Rezoning Transportation Analysis

Petition Number: #2022-048

From: Jake Carpenter, PE

Date	Description
08-25-22	First Review (PDM)
09-22-22	Second Review (PDM)
10-27-22	Third Review (TM)
11-28-22	Fourth Review (TM)

RZ-2

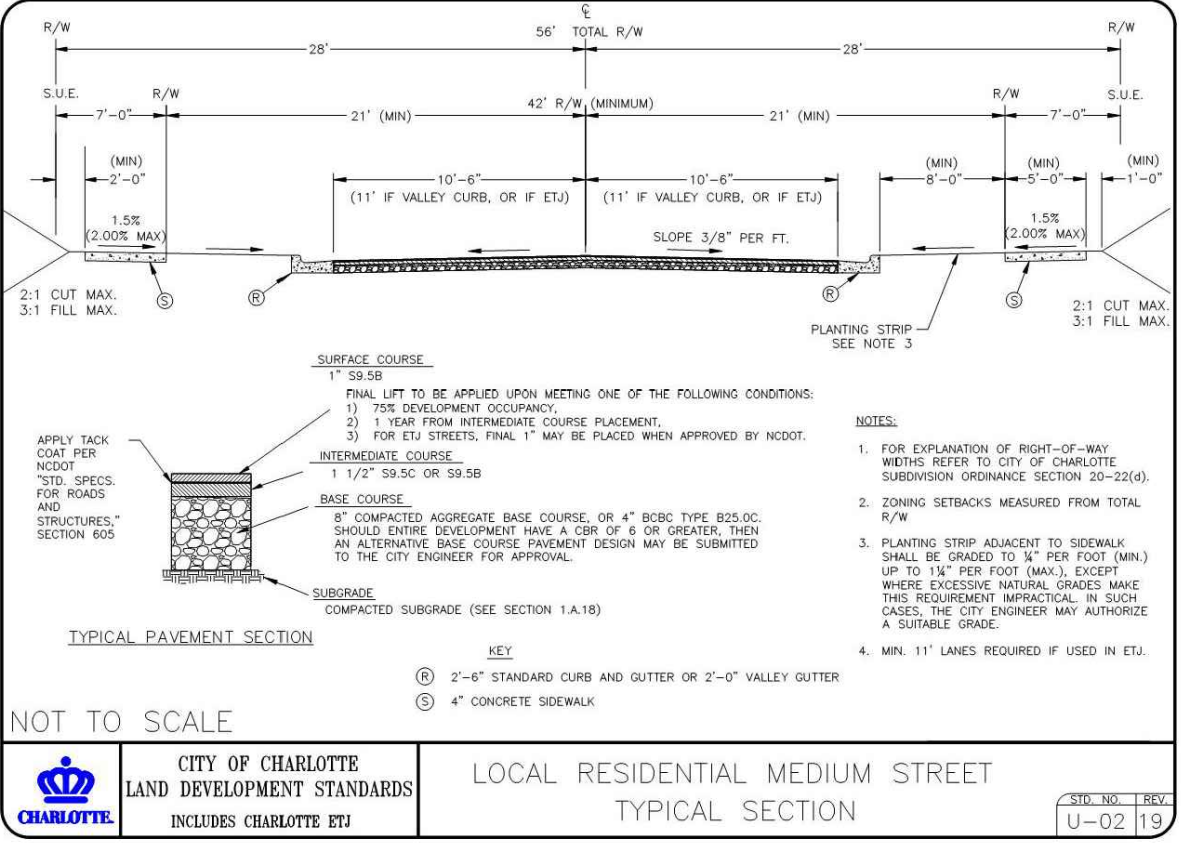
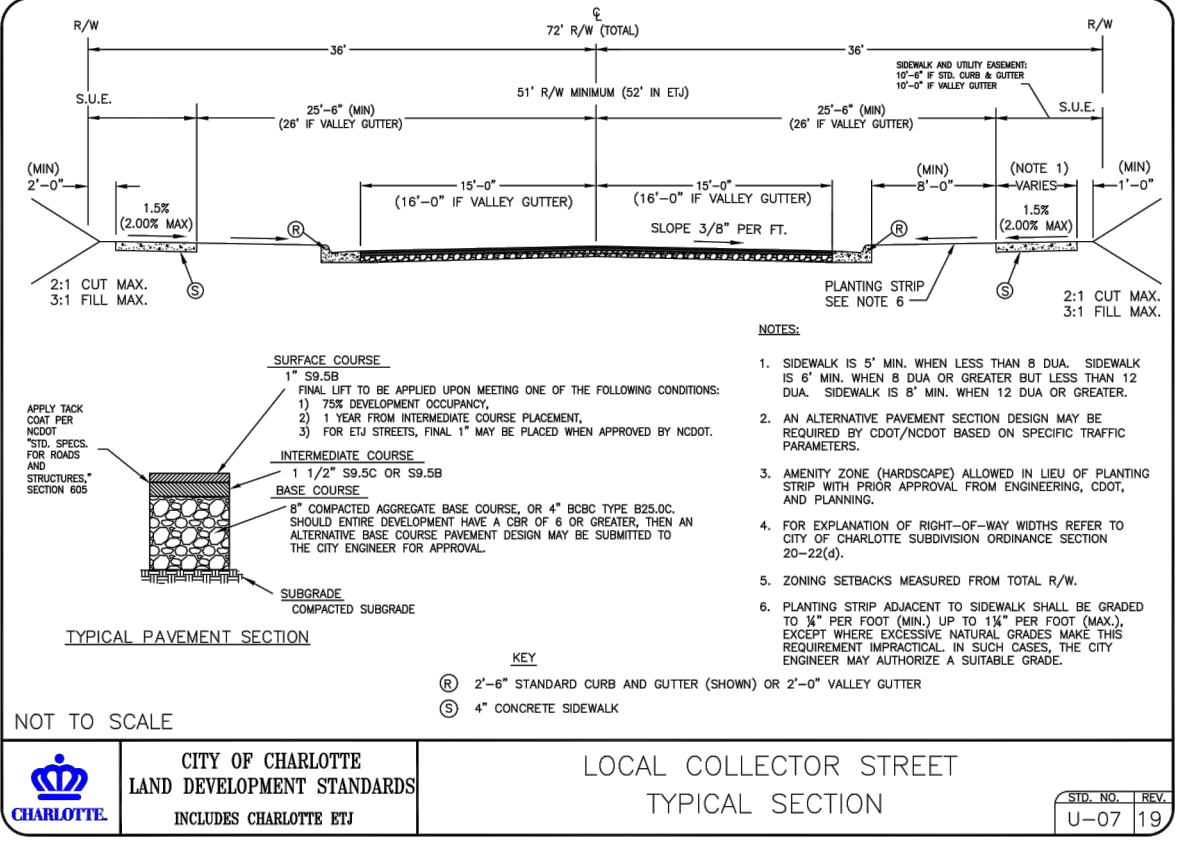
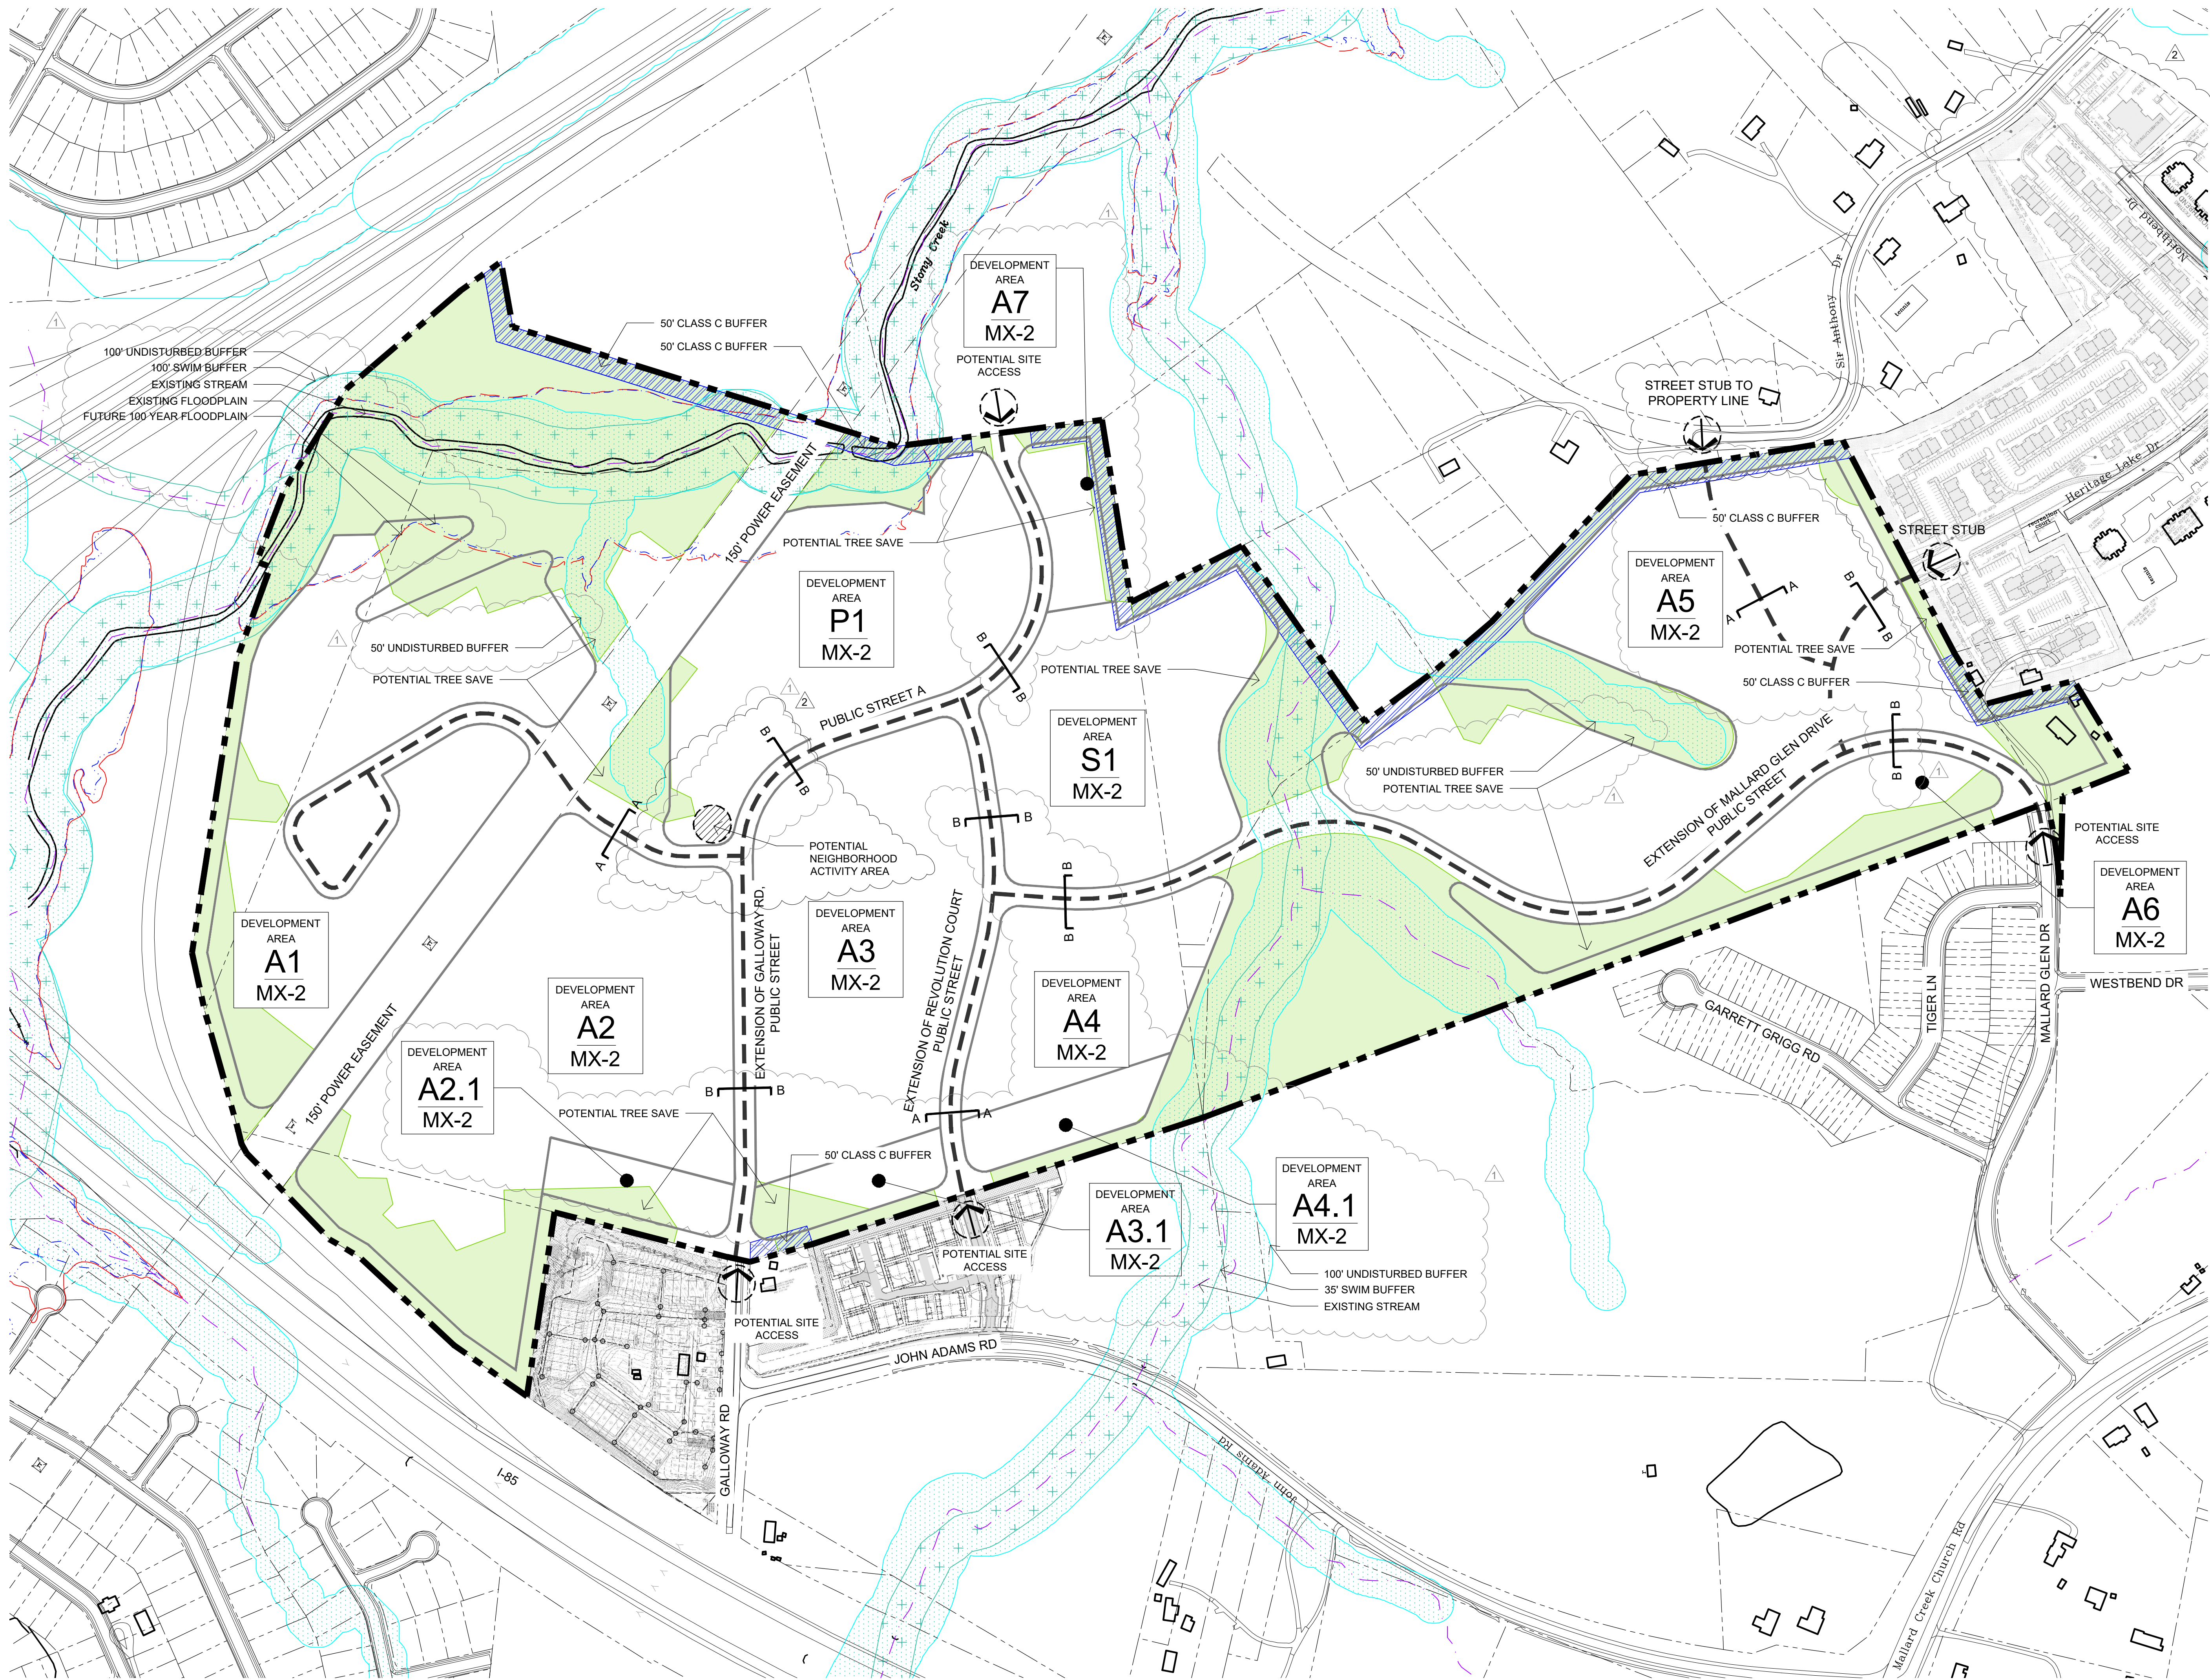
~~2. Outstanding Comment from 08-25-22: Revise site plan and conditional note(s) to commit to improving the existing Galloway Road stub to John Adams to the local collector street typical section per U-07.~~

- ~~3. Revise site plan and conditional note(s) to commit to the proposed roadway network typical sections and proposed phasing outlined in the Traffic Impact Study. Provide typical sections per CLDSM for all proposed public and private streets. Provide 8 foot sidewalk and 8 foot planting strip on all public streets.~~
